CITY OF ALBUQUERQUE

April 2, 2018

**RE: Primrose School
Grading Plan
Engineer's Stamp Date: No Date
Hydrology File: C13D029**

Based upon the information provided in your submittal received 03/21/2018, the Grading Plan **is not** approved for Building Permit and Grading Permit. The following comments need to be addressed for approval of the above referenced project:

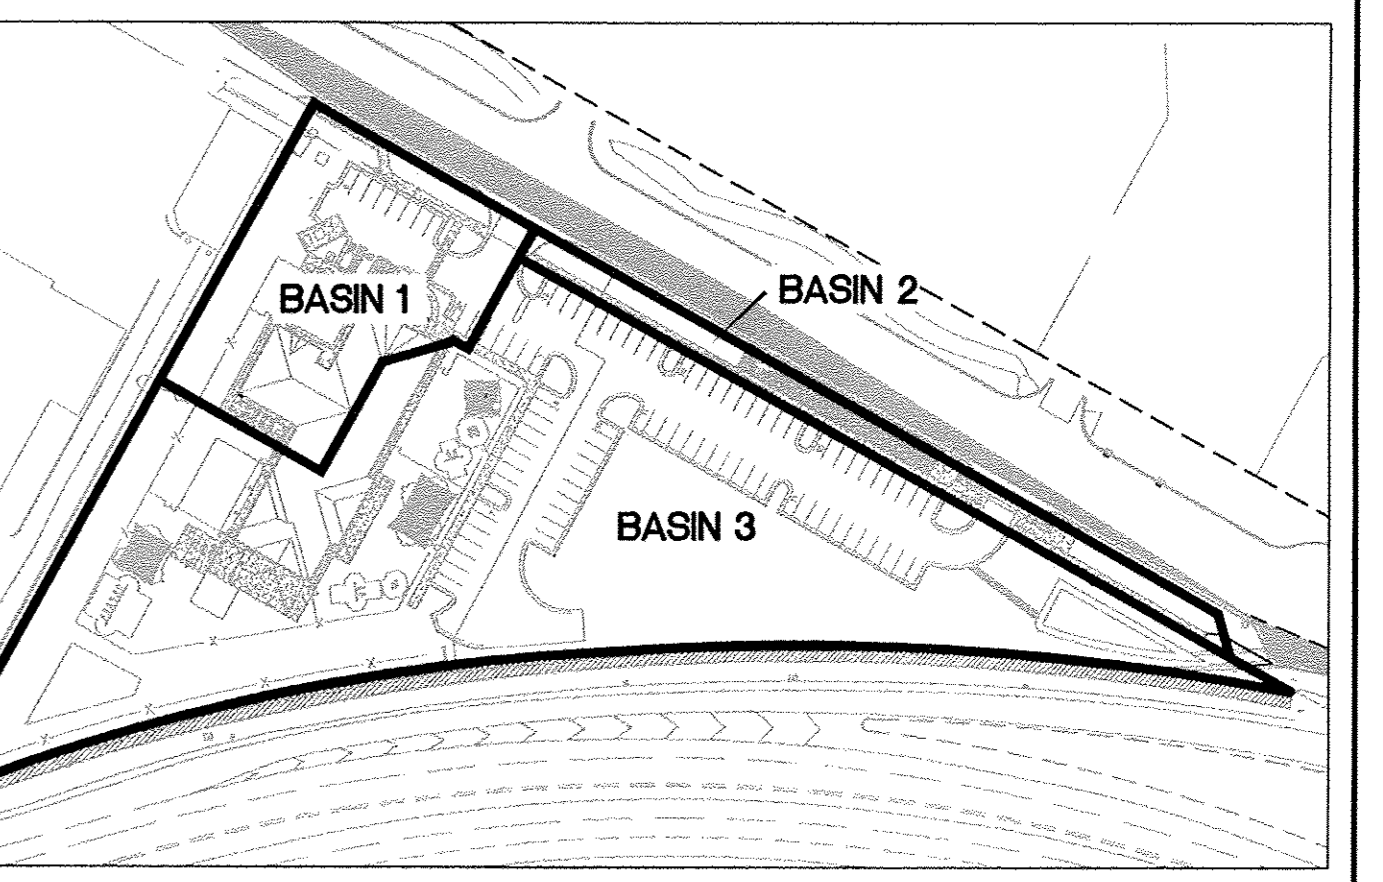
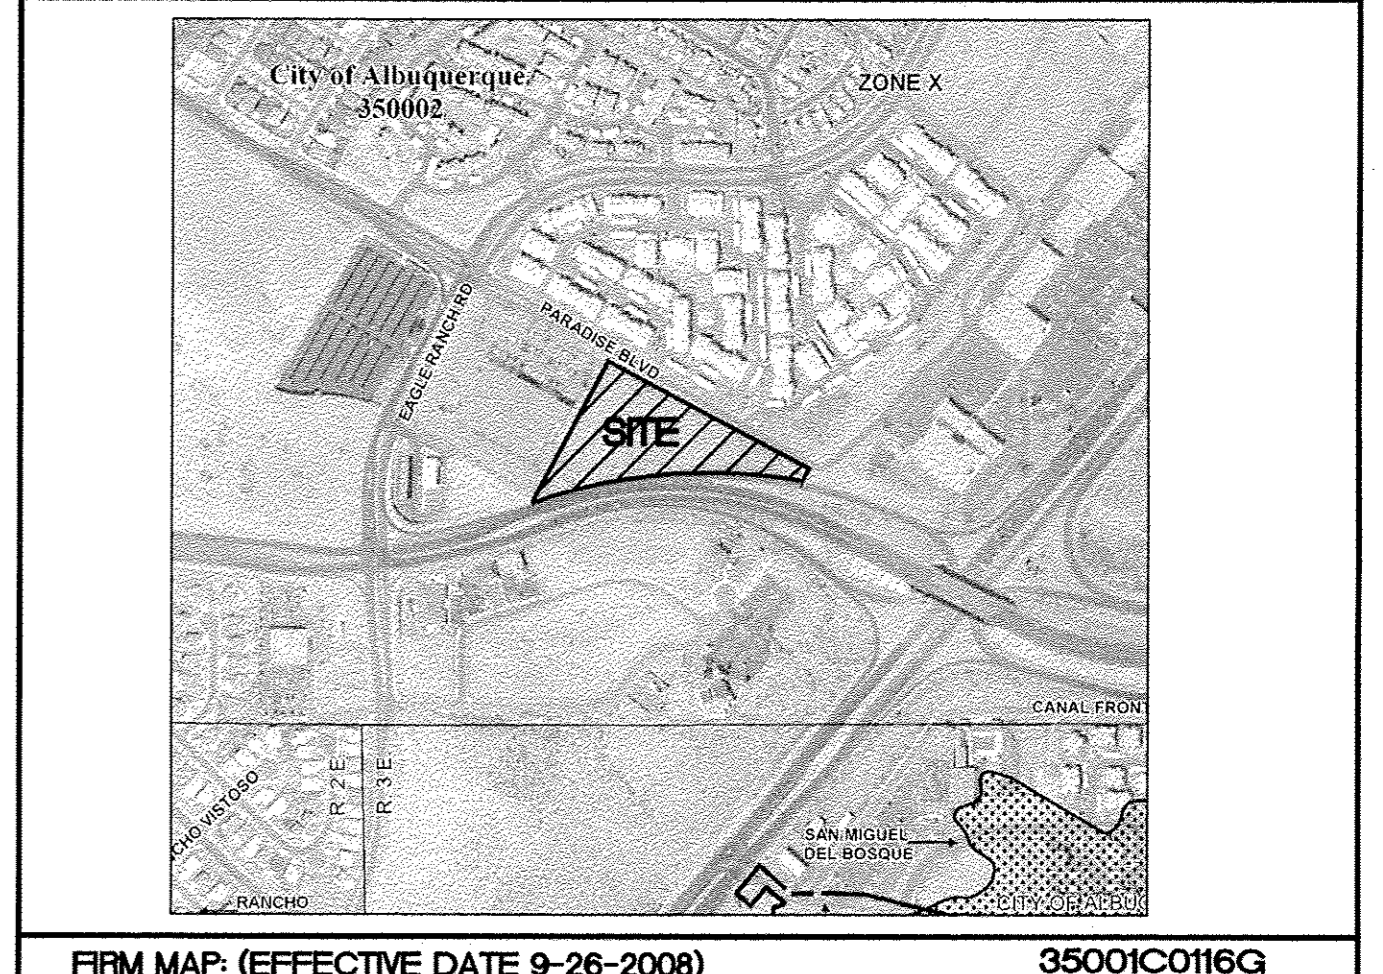
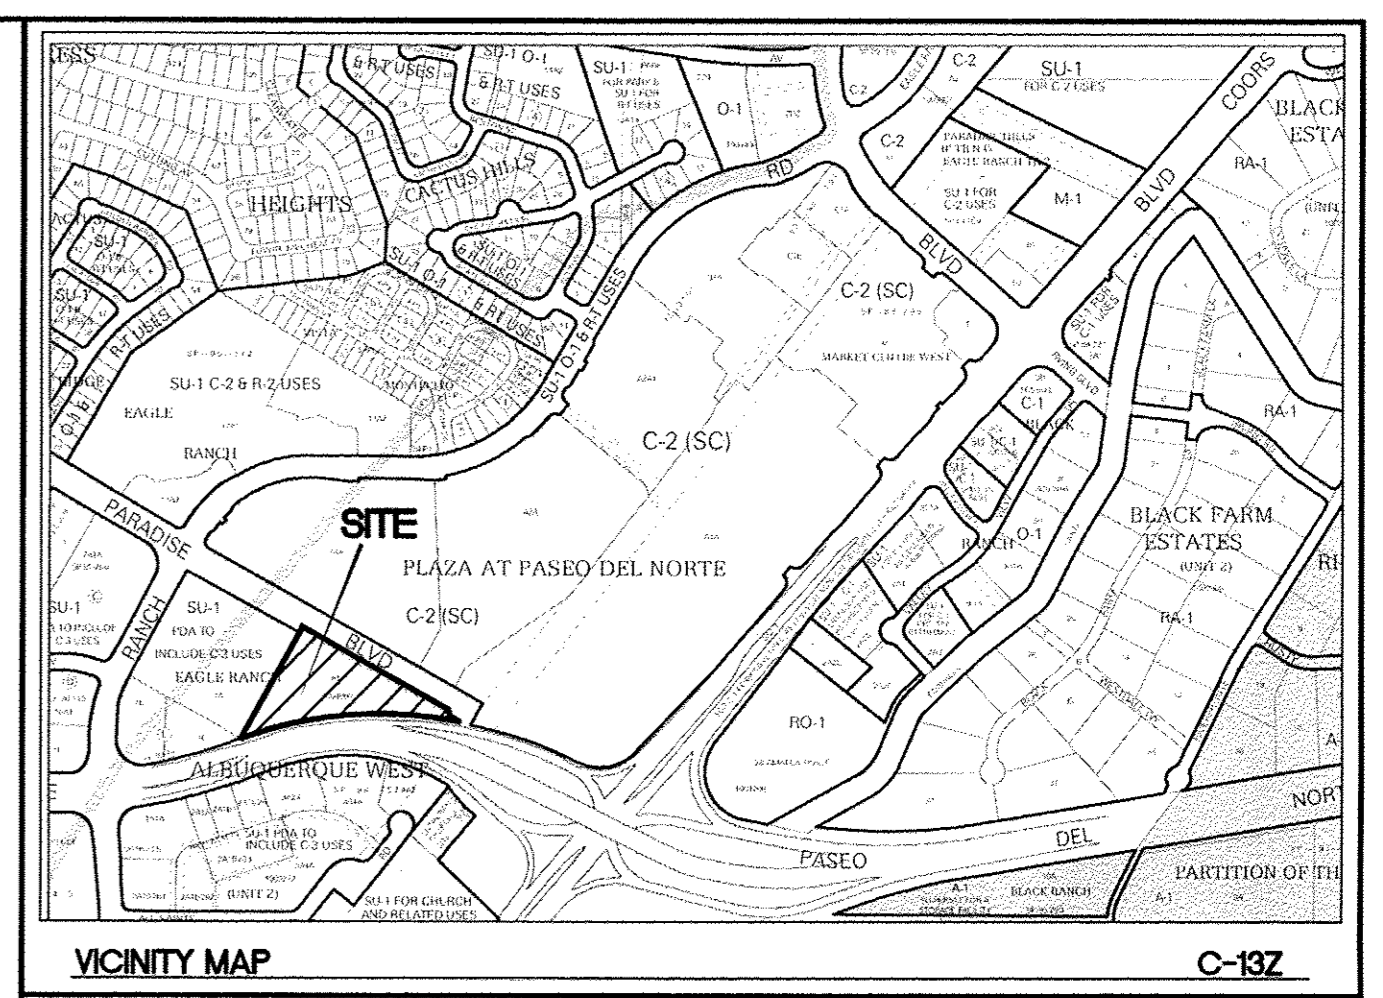
7. Please show existing top of curb information along Paseo Del Norte at least at 50 feet apart.
8. Please show the existing drop inlet drainage information within Paseo Del Norte.

9. Please provide proposed elevations at both edges of the 10 ft asphalt trail, top of bank, flow line, and top of bank at 50 feet intervals along the southern property line.

10. There are missing grades within the proposed parking areas. Please provide them.
11. Please indicate if the proposed spot elevations within the proposed parking area are the top of curb or flow line information.

12. What is the purpose of the 20' Drivable grass? If it is for fire protection, then the firetrucks can only drive on a 2% max slope. Please fix.
13. Please correct the first flush calculation to 2,234 CF instead of 2.234 CF.

14. Please provide the weir calculation for the 3 ft curb cut.
15. Please provide a typical section of the 3 ft cobble swale.
16. Please provide proposed top of curb along Paradise Blvd.
